FINAL SITE GRADING CONSTRUCTION PLANS
FOR
CREEKSIDE AT LORSON RANCH FIL. NO. 2
FINAL OVERLOT GRADING / EROSION CONTROL PLANS

PROJECT:
CREEKSIDE AT LORSON RANCH 2
LORSON BLVD. TRAPPE DR.
COLORADO SPRINGS, COLORADO

COVER SHEET
FINAL GRADING AND
EROSION CONTROL PLAN

**TYPICAL SECTION 50' R.O.W.
RESIDENTIAL URBAN LOCAL**
NOT TO SCALE

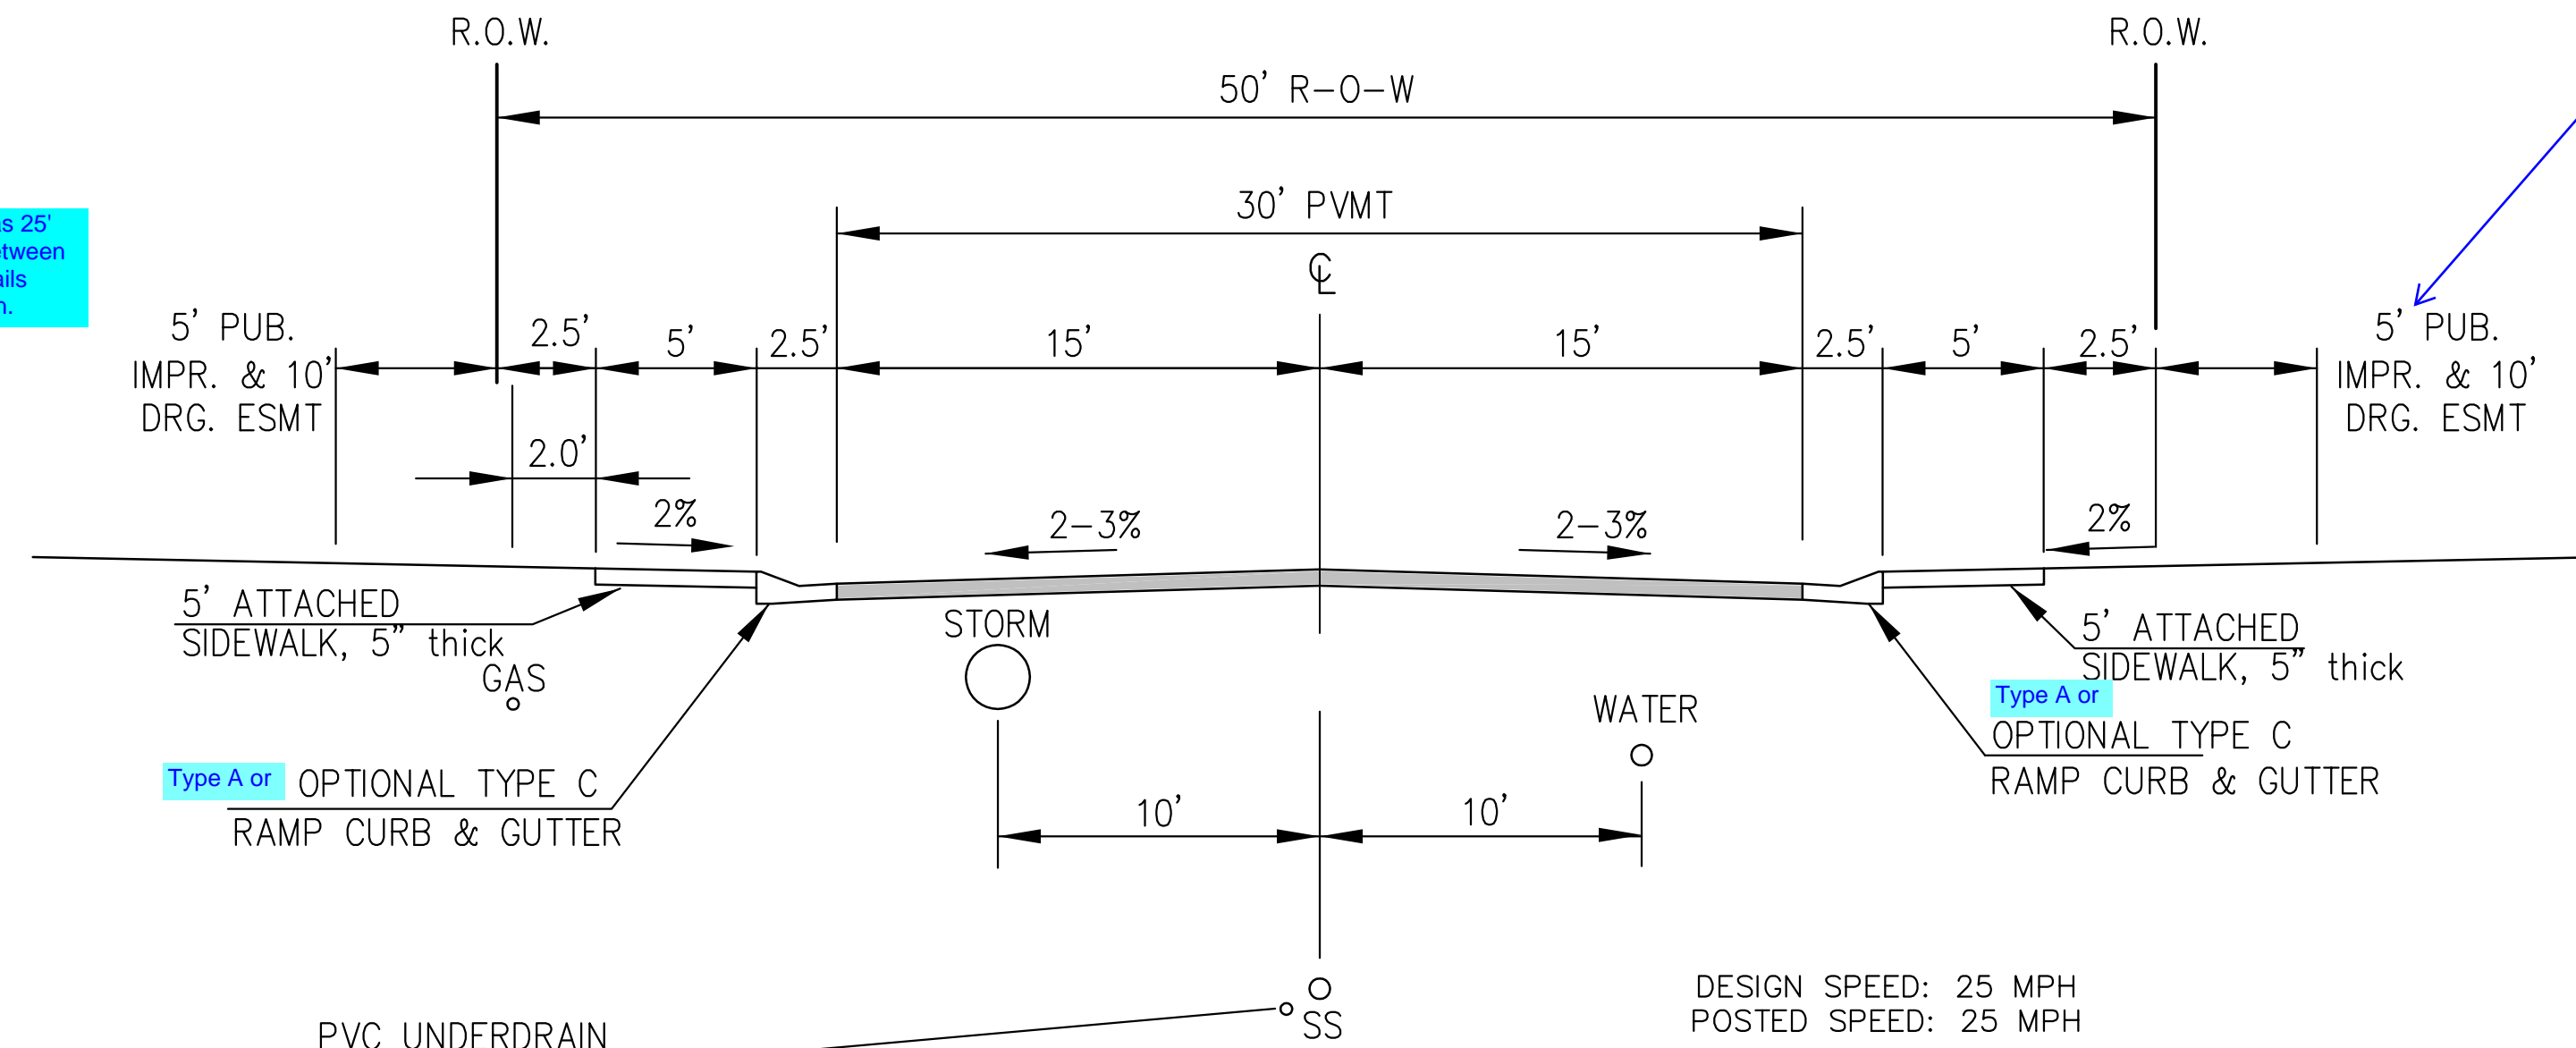
Per typical section on CD's, public improvement easement is 5'. Update sections between plan sets to be consistent.
